Your ref: TR010039

6 May 2022

PROPOSED CHANGES TO APPLICATION BY NATIONAL HIGHWAYS FOR AN ORDER GRANTING DEVELOPMENT CONSENT FOR THE A47 WANSFORD TO SUTTON SCHEME (TR010039)

DRAWING NUMBER
HE551494-GTY-HKF-000-DR-CH-31003

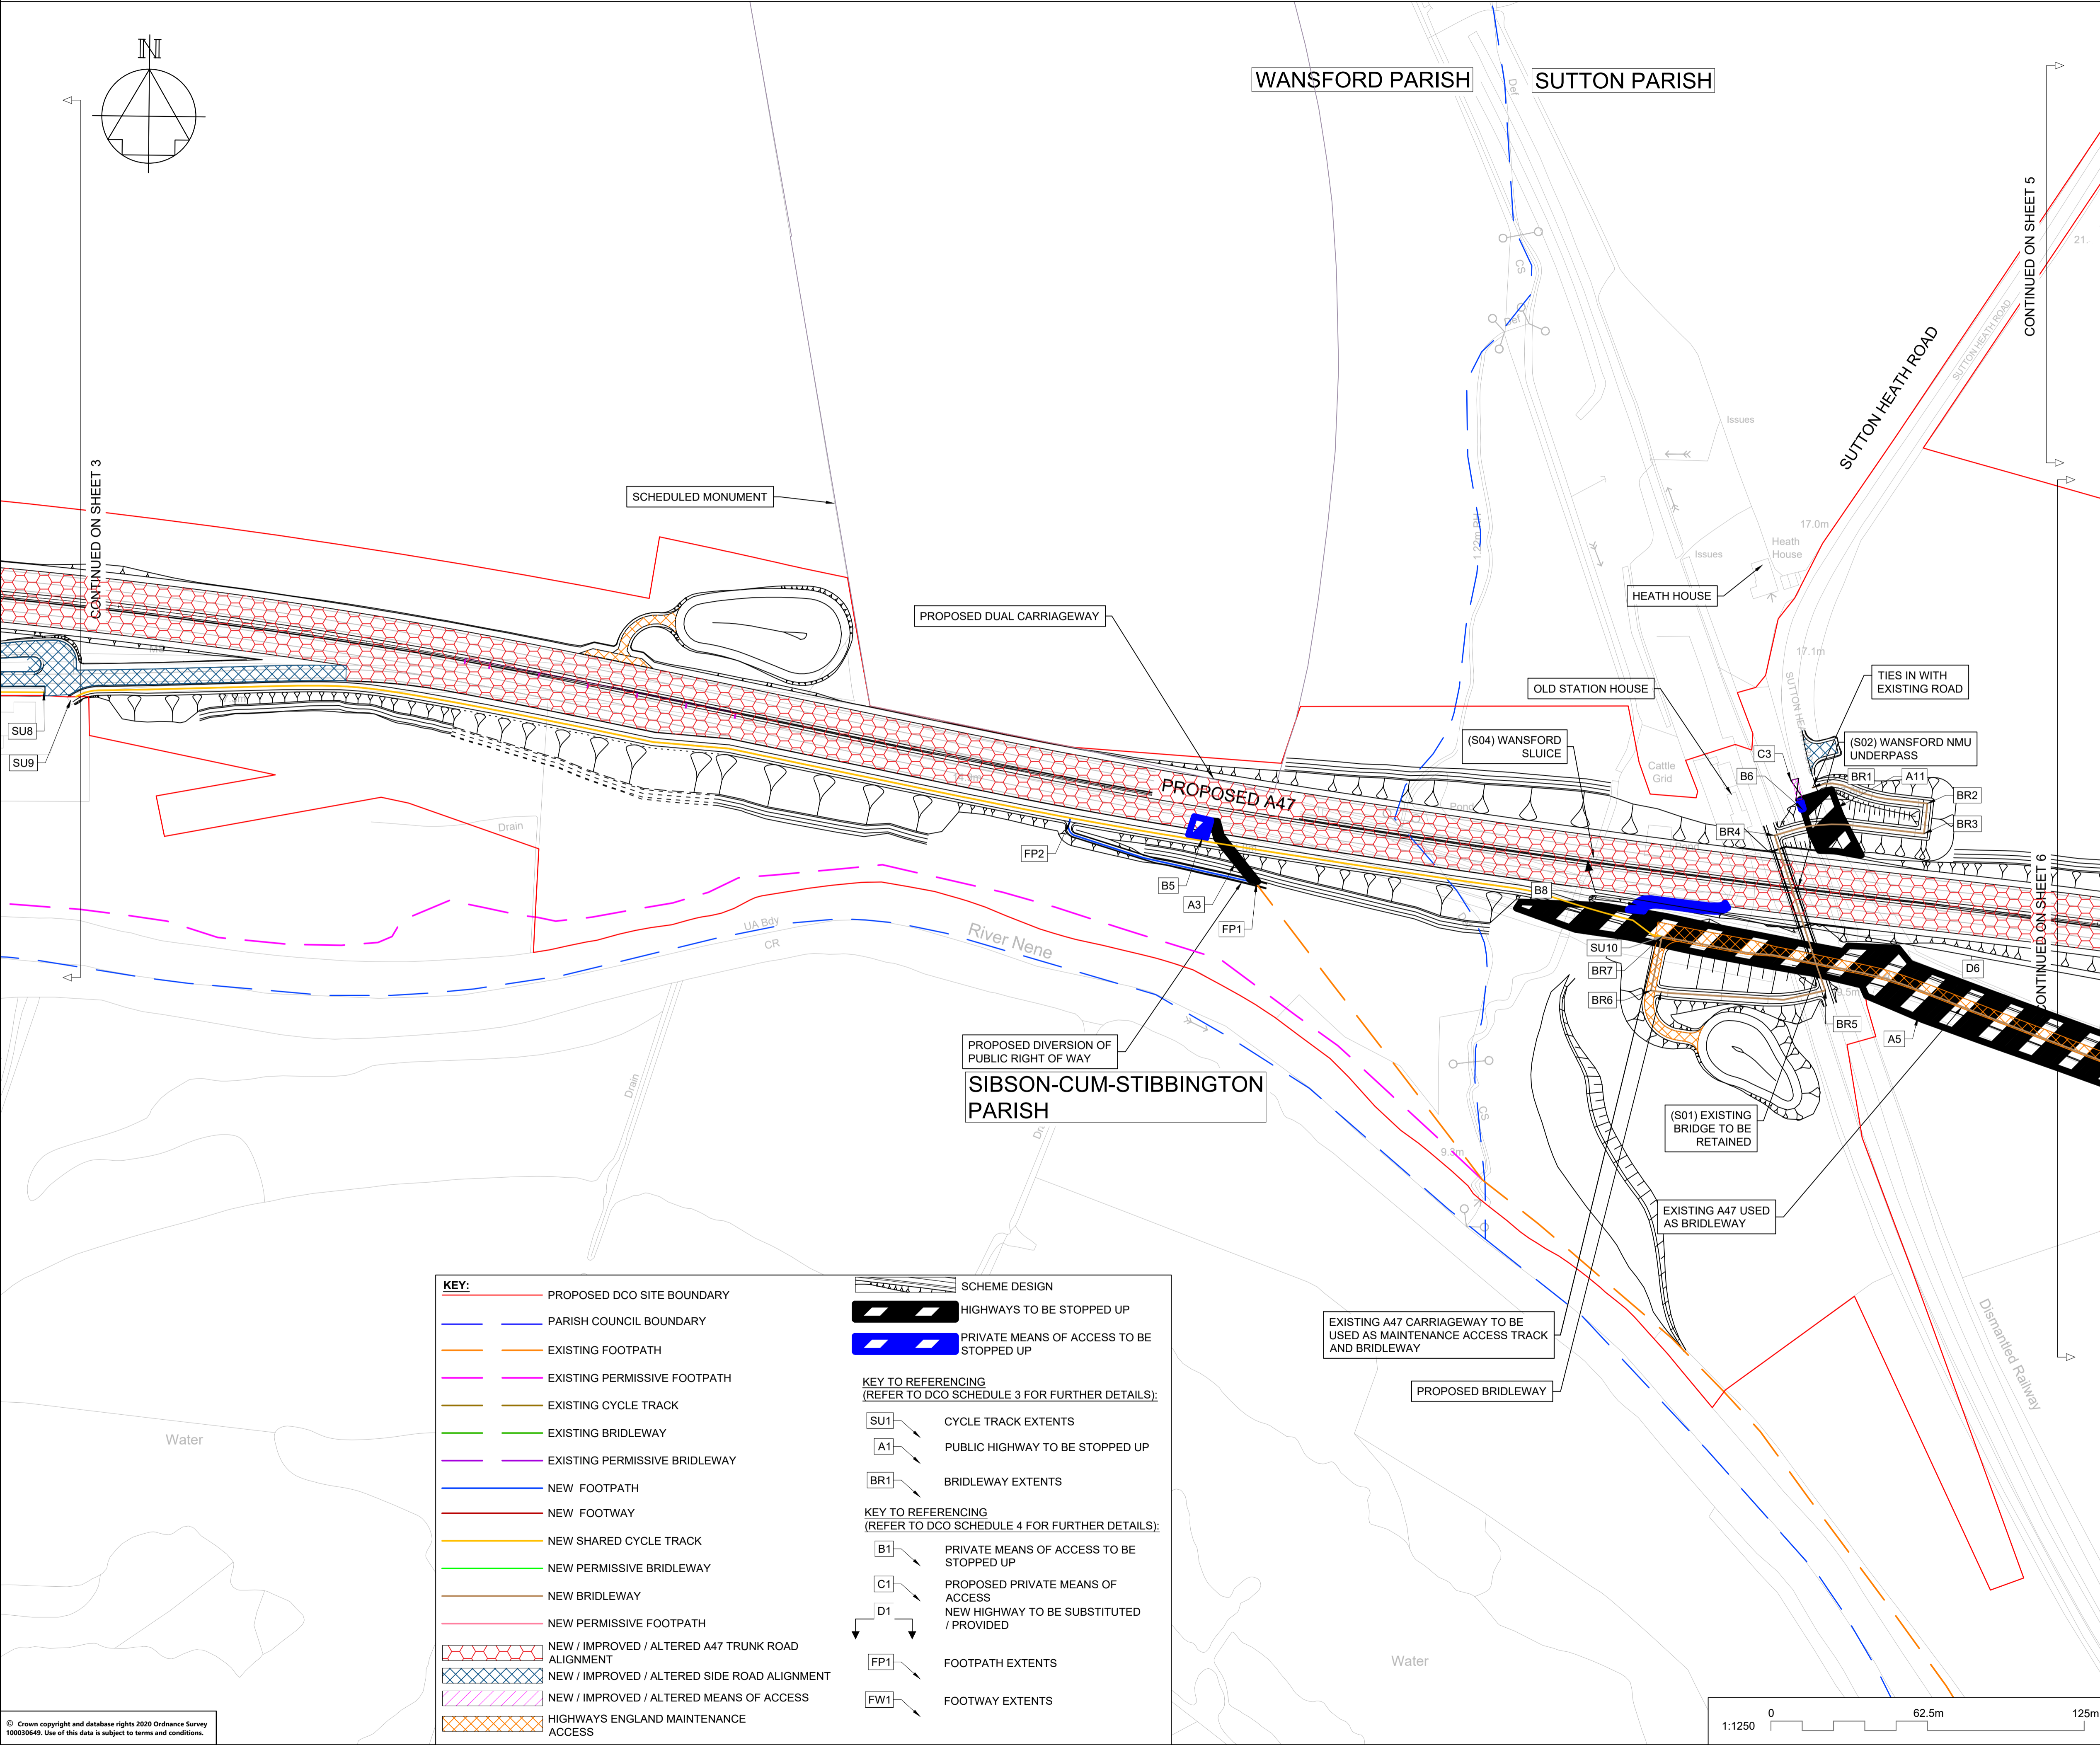
- (a) **Change Two:** Modification to the means of access alignment to Sacrewell Farm to avoid interface with Anglian Water assets shown on drawing HE551494-GTY-HKF-000-DR-CH-31003. This layout improves the visibility at the access to Sacrewell Farm and addresses the ExA's query at Hearing Action Point 38 and the Applicant's initial response regarding use of a convex mirror to improve visibility.
